**COMPLETED** 10/15/07 SH  
**DRB CASE ACTION LOG (PREL & FINAL)**  
REVISED 10/08/07

DRB Application No.:07DRB-70291	Project # 1006855
Project Name: <b>MONKBRIDGE ADDITION</b>	
Agent: SURVEYS SOUTHWEST LTD	Phone No.:998-0303

**CITY OF ALBUQUERQUE  
PLANNING DEPARTMENT  
October 10, 2007  
DRB Comments**

**RE: E 140' of Lot 1 & E 140' of the N 30' of Lot 2, Block 17,  
Monkbridge Addition/p&f**

**PLAT OF
LOT 1-A, BLOCK 17
MONKBRIDGE ADDITION
PROJECTED SECTION 5, T. 10 N., R. 3 E., N.M.P.M.
TOWN OF ALBUQUERQUE GRANT
CITY OF ALBUQUERQUE
BERNALILLO COUNTY, NEW MEXICO
SEPTEMBER 2007
SHEET 2 OF 2**

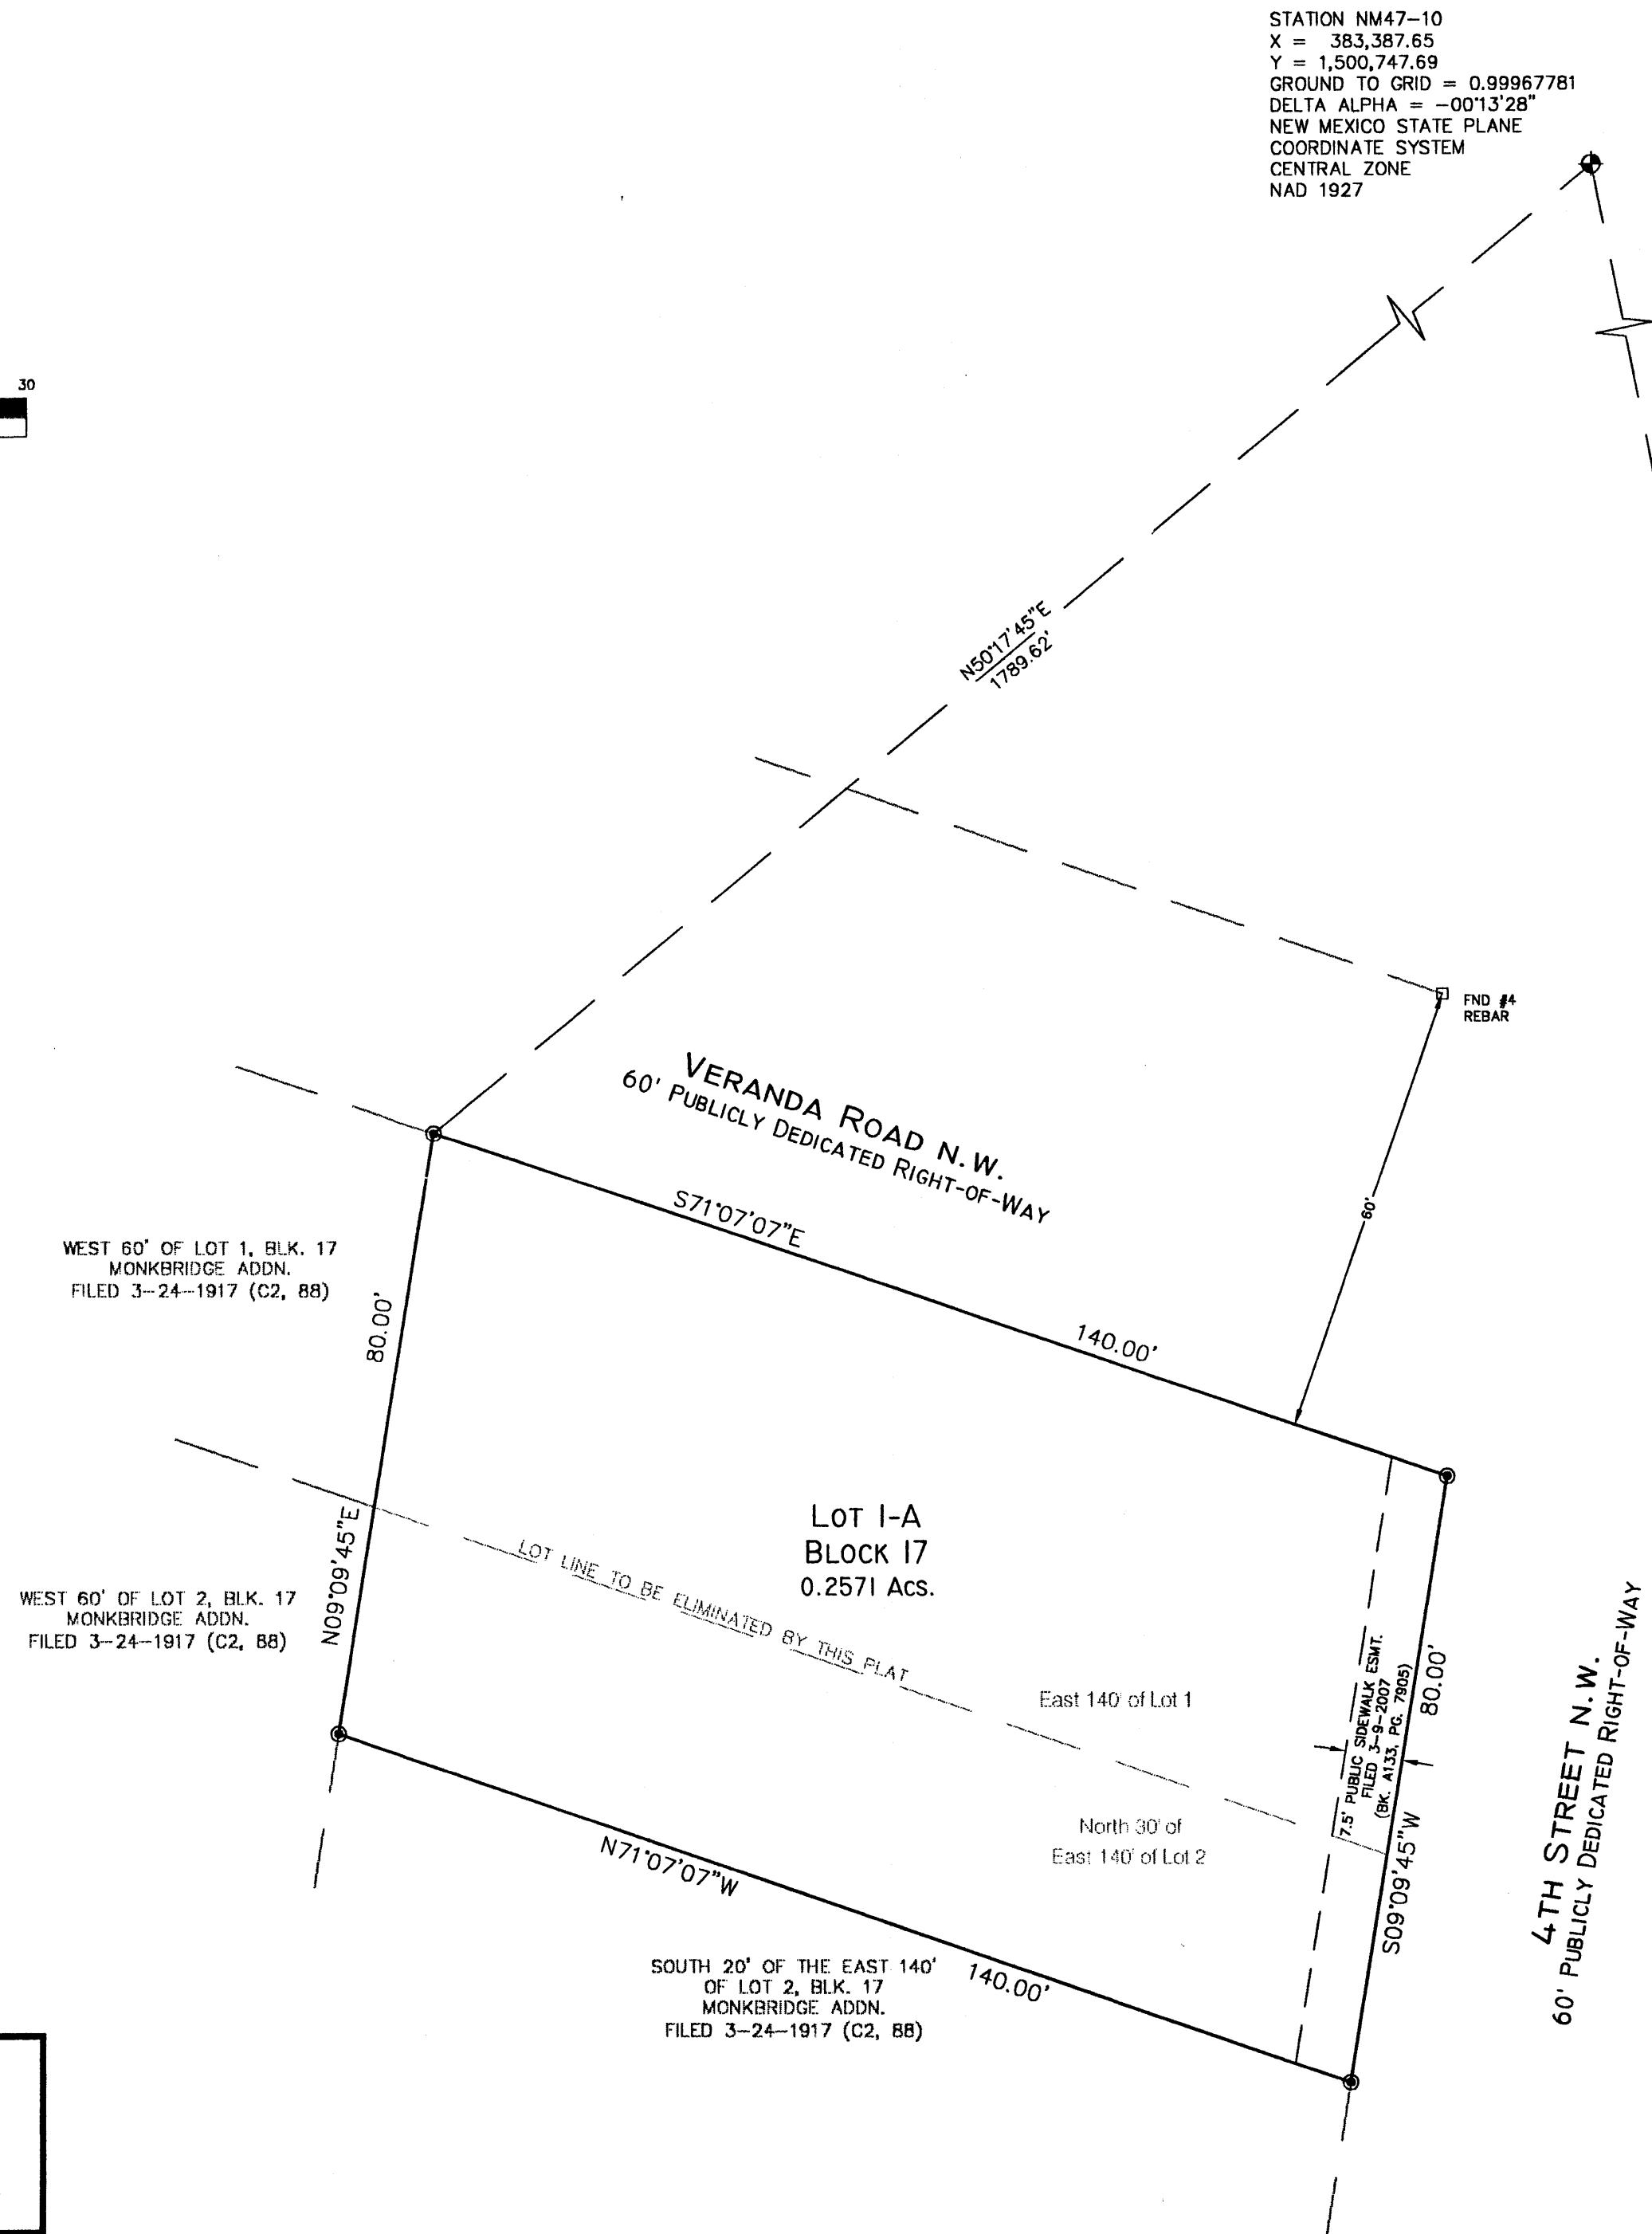
TRANSPORTATION: 20' radius
